RESPONSE TO E.I.S. SUBMISSIONS

ISSUE 1 – 6 October 2016

HUNTER SPORTS HIGH SCHOOL MAJOR CAPITAL WORKS PACIFIC HIGHWAY GATESHEAD NSW 2290

ANNEXURE F: CONCEPT SOUTHERN CARPARK ACCESS

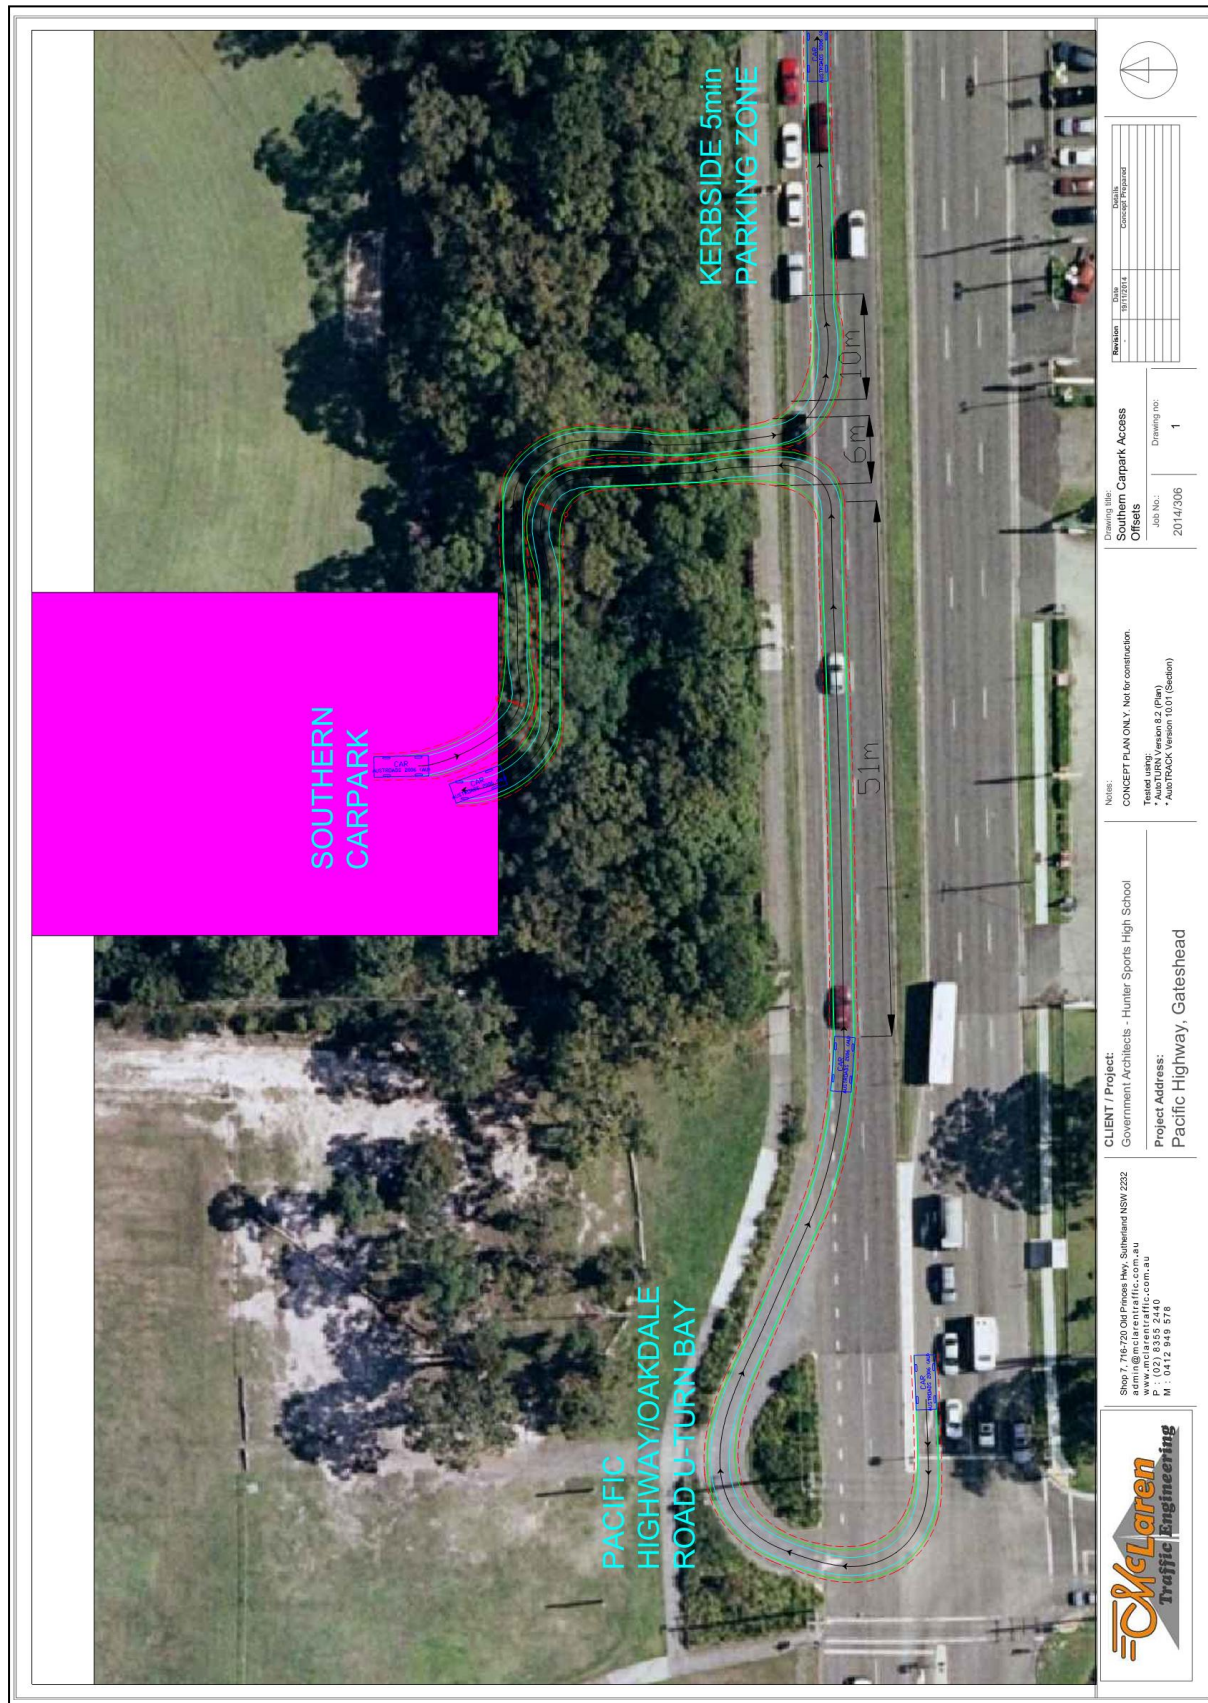
Agency	Issue	Response
1.0 Planning & Environment	1.1 Clarification of proposed on site car parking arrangements, including existing formal and informal parking spaces, proposed parking spaces and location and any works in parking areas.	Refer to detail provided in Appendix 17d of the EIS, including attachment drawings contained in Annexures A and B to that appendix. In summary, the parking arrangements are: EXISTING CARPARKS - 43 formal marked car spaces; - Approx. 27 informal unmarked car spaces. Total of approximately 70 existing car spaces. PROPOSED CARPARKS - 8 formally marked car spaces retained in proposed redevelopment; - 26 informal unmarked car spaces retained in proposed redevelopment (southern informal carpark); - Additional 36 informal unmarked car spaces provided in proposed redevelopment (northern informal carpark). Total of 70 car spaces provided in proposed redevelopment.
